Epping to Thornleigh Third Track Proposal. Application number SSI 5132.

Name(s): IAN & ELIZABETH RAMSAY

I/we object to the Epping to Thornleigh Third Track Proposal and consider that the EIS is inadequate and does not address the full impact of this proposal. It will cause untold damage to the health of residents and to the fabric of the Beecroft Cheltenham Heritage Conservation Area. Do not approve this project, reconsider the alternatives and protect the community.

Figure S.6 Cross-section and elevation - New Cheltenham Station concourse building (see also S.5 for artist's impression)

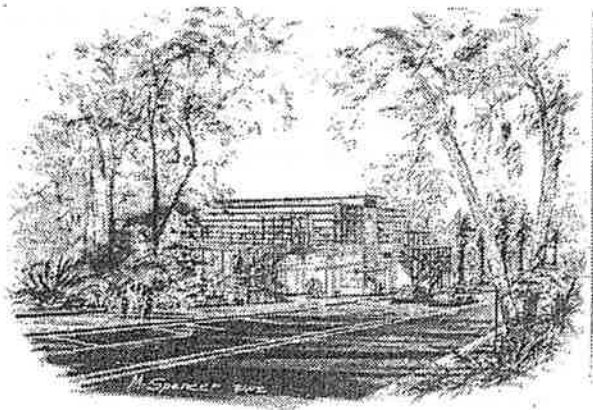
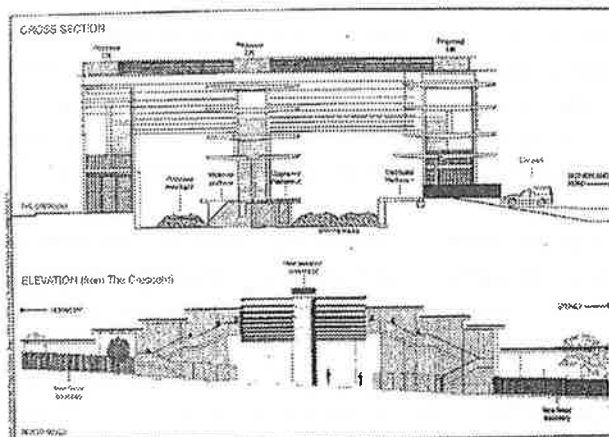
- The proposed redevelopment of Cheltenham Station shows no regard for the HCA. The visual impact of the proposed 13m high glass and steel concourse is totally unacceptable in this HCA.
